Application by NNB Generation Company (SZC) Limited for an Order Granting Development Consent for The Sizewell C Project

The Examining Authority's written questions and requests for information (ExQ1)

Issued on 21 April 2021

DRAWING TITLE:
SUFFOLK COAST PATH AND FUTURE ENGLAND
COAST PATH DIVERSIONS -
CONSTRUCTION PHASE

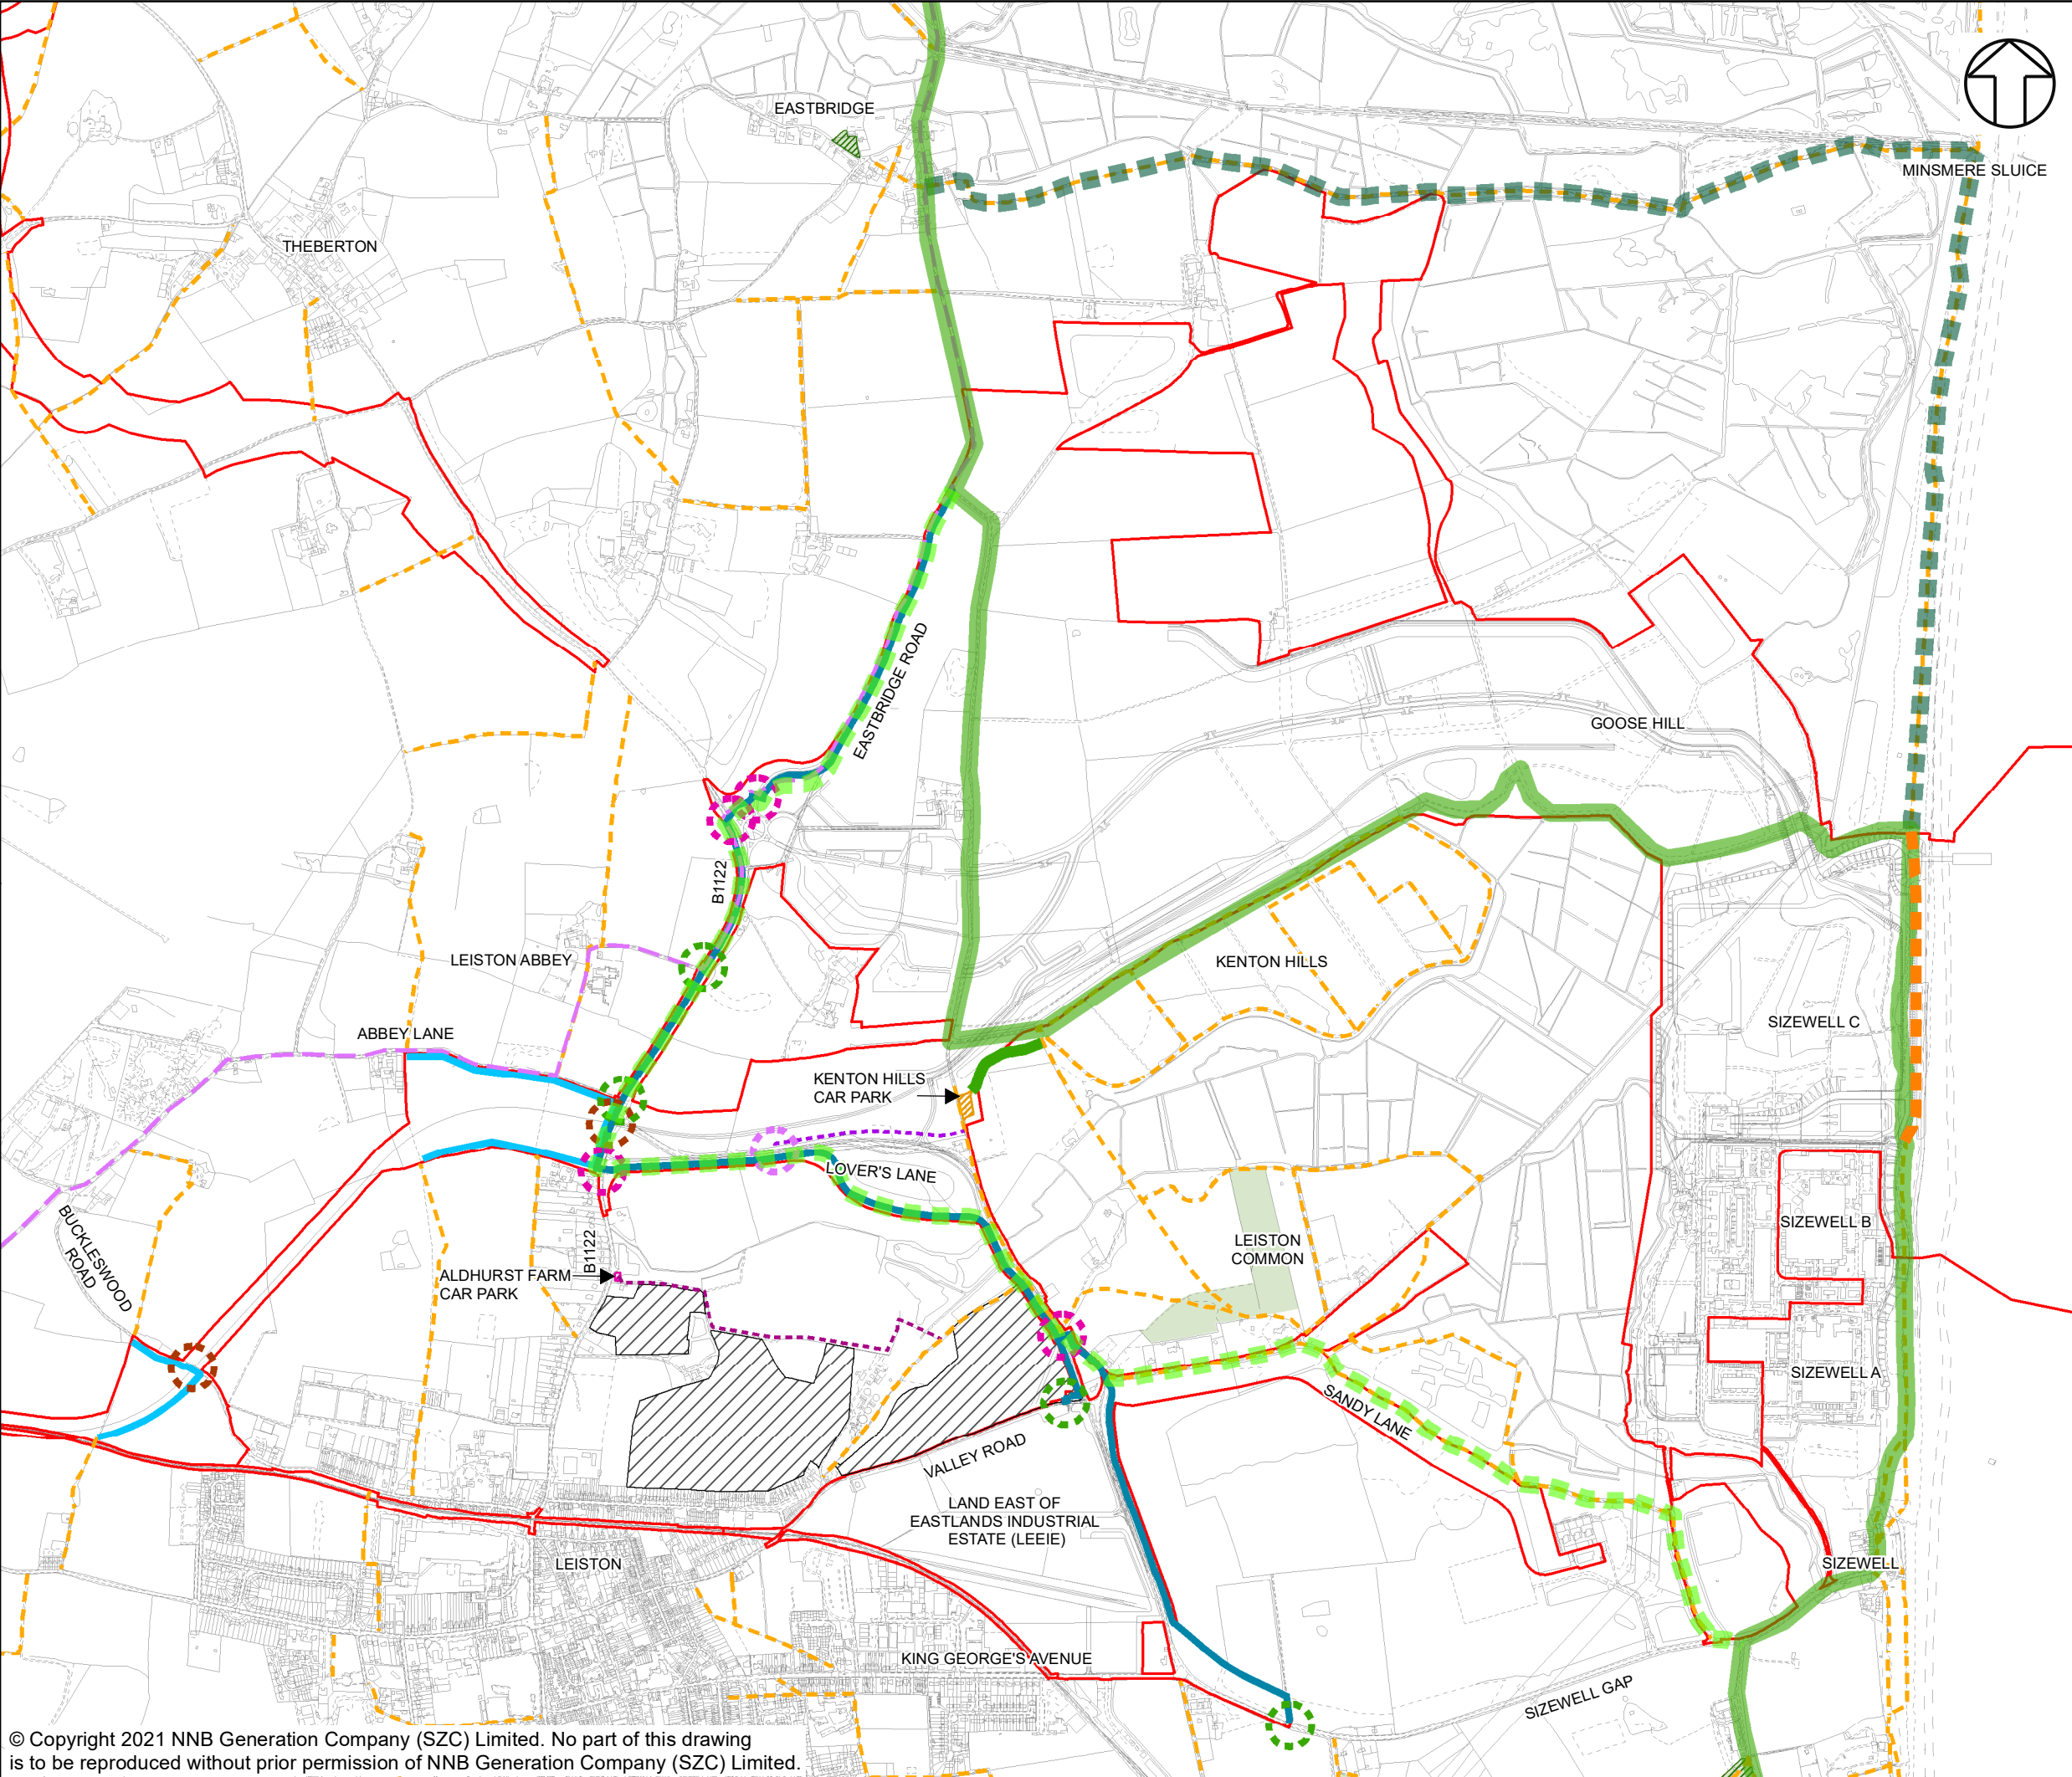
G.1.40	The Applicant	Permanent and Temporary BLF – Diversion of Coastal Paths Paragraph 15.5.11 to 15.5.20 [APP-267] sets out the potential implications for the Suffolk Coast Path, Sandlings Walk and the future route of the England Coast Path. Diversions are explained and shown in The Access and Rights of Way Strategy, Appendix 15I [APP-270]. The introduction of the new temporary beach landing facility is likely to affect the periods for which diversions would be in place. Set out the approximate length and frequency of closures associated with: (i) Construction of the permanent beach landing facility; (ii) Construction of the temporary beach landing facility; (iii) Operation of the permanent beach landing facility during construction; (iv) Operation of the temporary beach landing facility when conveyor belt is in use, if closure of path beneath is required; and
